EP-21-0051_1 Waterbury PUD Preliminary Plan

SW ¼ SW ¼ Section 28, T12S, R64W, 6th P.M.
38.9718, -104.5693

Colorado Geological Survey has reviewed the Waterbury PUD preliminary plan referral. I understand the applicant proposes 201 single-family residential homes on approximately 62 acres located southeast of Highway 24 and Stapleton Road in Falcon.

TEST BORING/ PERCOLATION TEST
LOCATION PLAN
4 - WAY JOINT VENTURE
WATERBURY PHASE 1
EL PASO COUNTY, CO
FOR: 4-WAY JOINT VENTURE

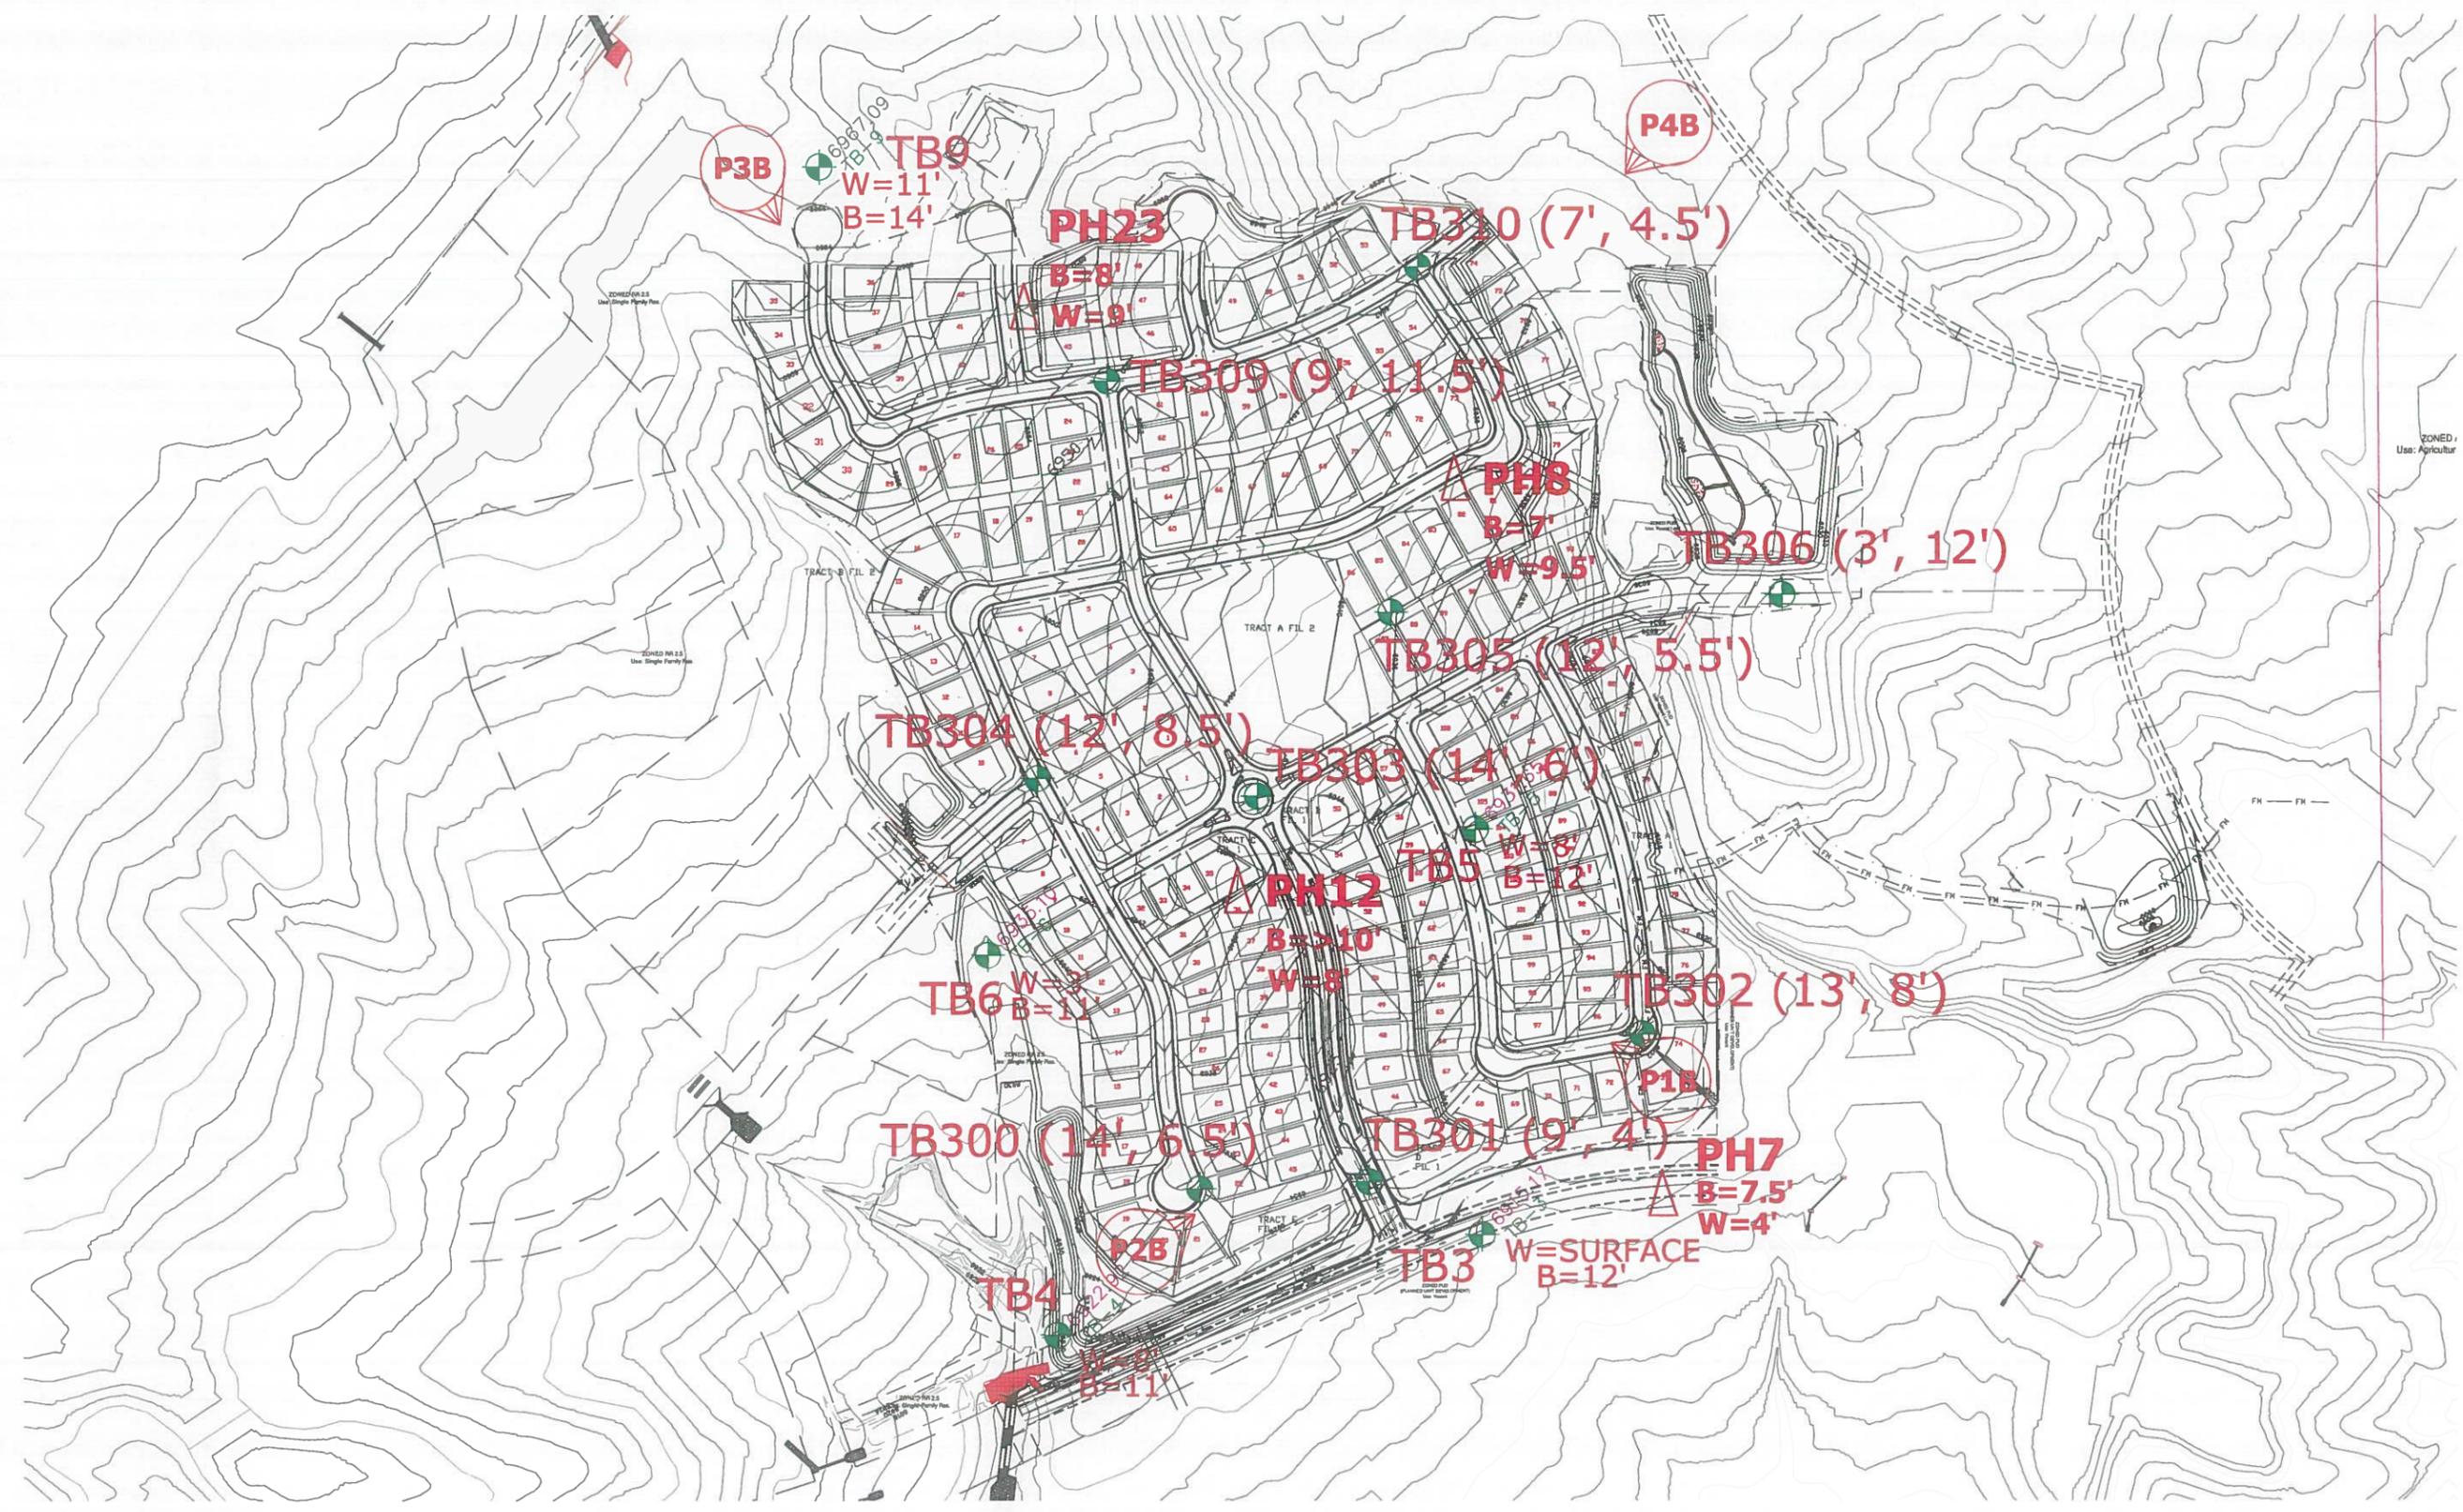
Geologic Hazard Disclosure Statement. CGS recommends a geologic hazard disclosure statement is included on the preliminary plan referencing Entech’s March 22, 2013 report and December 23, 2020 addendum for mitigation measures and the “Geology/Engineering Geology Map” (figure 3).
